Our ref: NO/2017/109921/01-L01
Your ref: 3/2017/0408
Date: 30 June 2017

CHANGE OF USE OF SITE FROM RESIDENTIAL USE (C3) TO A COOKERY SCHOOL WITH ASSOCIATED ACCOMMODATION (C2), INCLUDING AN EXTENSION TO THE EXISTING DETACHED GARAGE BUILDING THORNEYHOLME HALL NEWTON ROAD DUNSOP BRIDGE BB7 3BB

The Environment Agency OBJECTS to the proposed development as submitted on the following grounds:-

Existing Ground Floor Plan

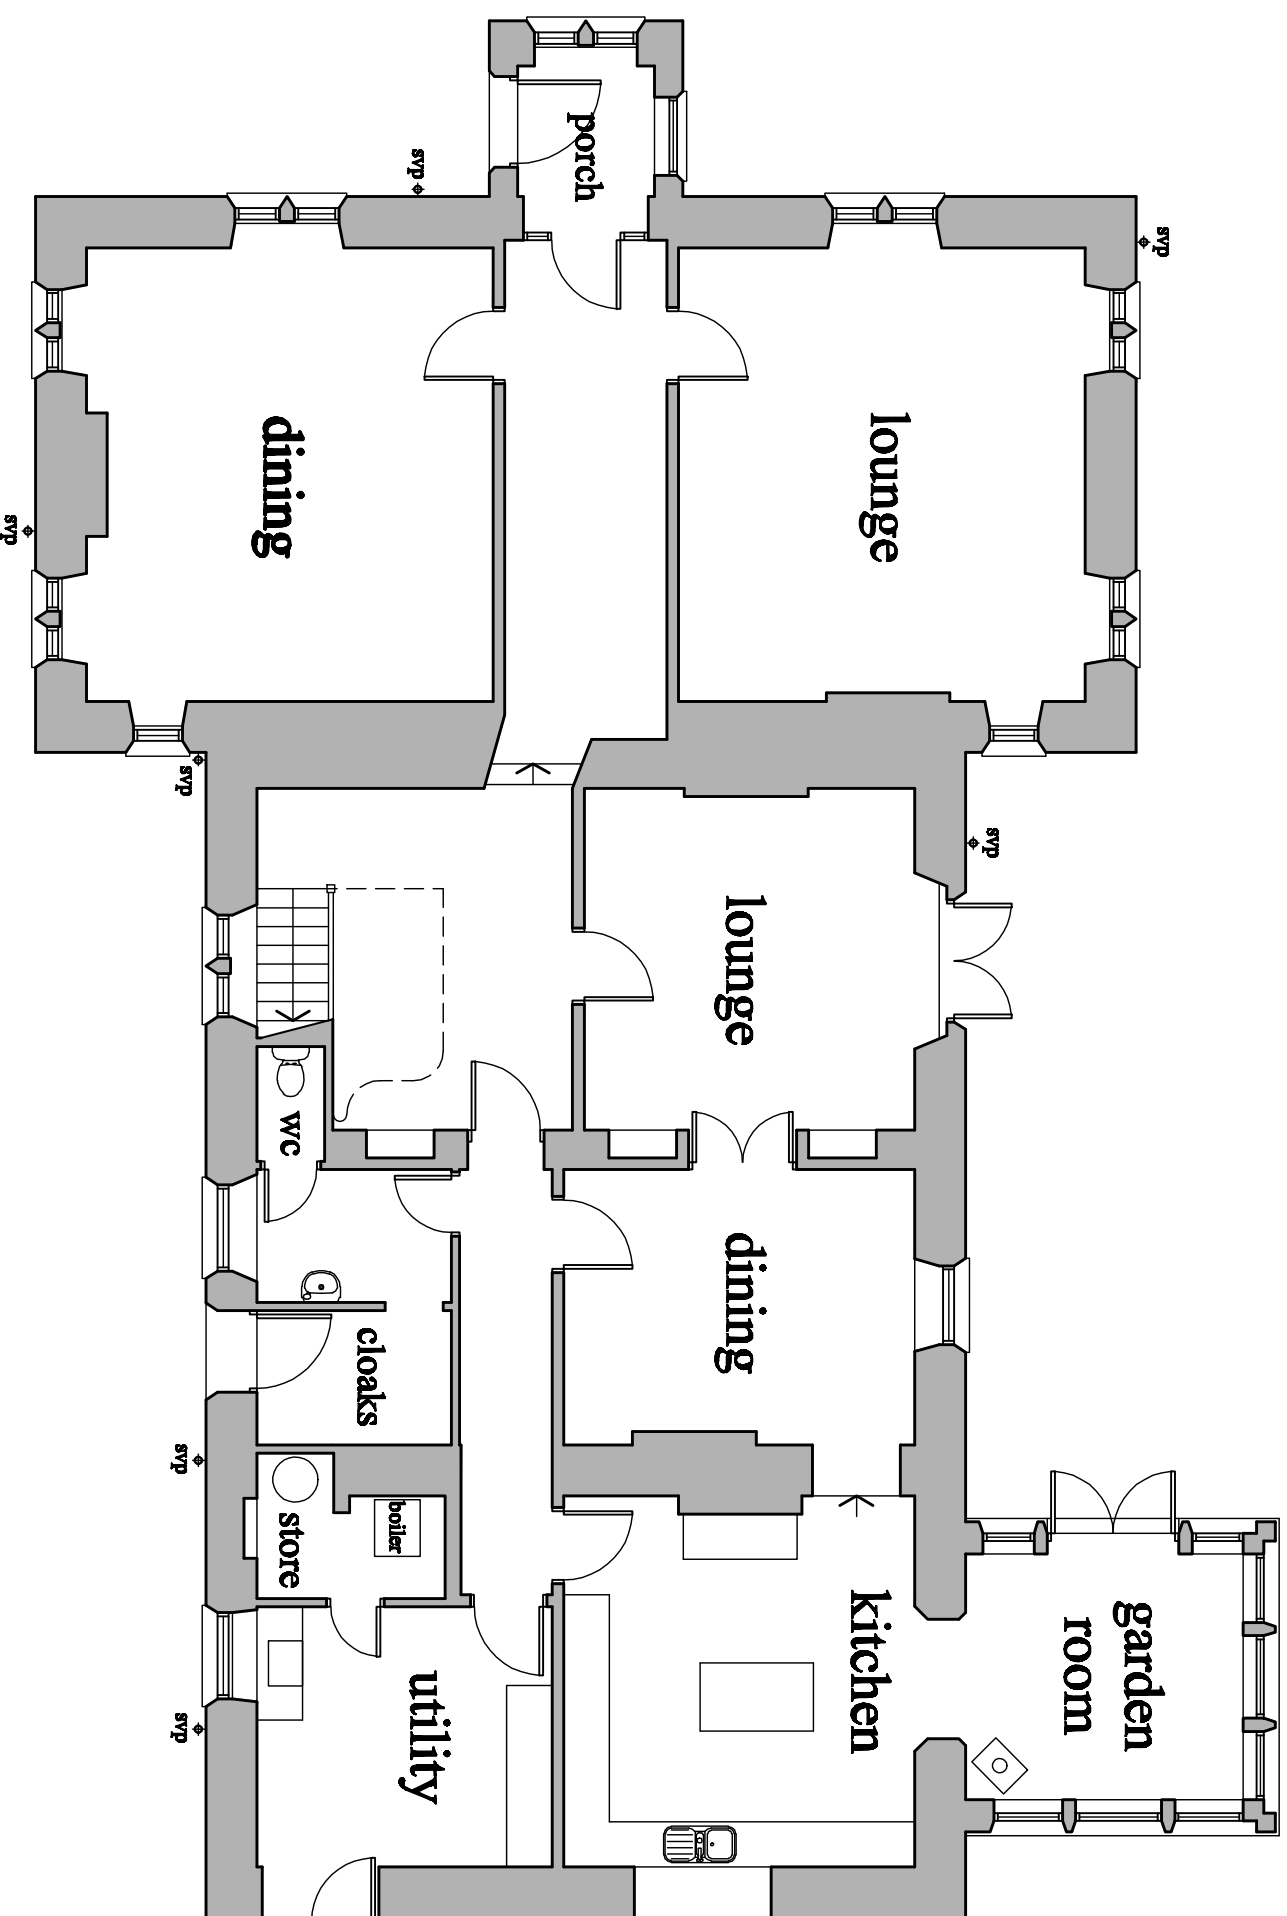
1. Consider how people will be kept safe from flood hazards identified. The proposed development includes sleeping accommodation on the ground floor. This not acceptable in the absence of any details regarding the finished floor levels as the risk to habitable accommodation has not been considered.
2. Consider the requirement for flood emergency planning including flood warning and evacuation of people for a range of flooding events up to and including the

The applicant can overcome our objection by submitting an FRA which covers the deficiencies highlighted above and demonstrates that the development will not increase risk elsewhere and where possible reduces flood risk overall. If this cannot be achieved we are likely to maintain our objection to the application. Production of an FRA will not in itself result in the removal of an objection.
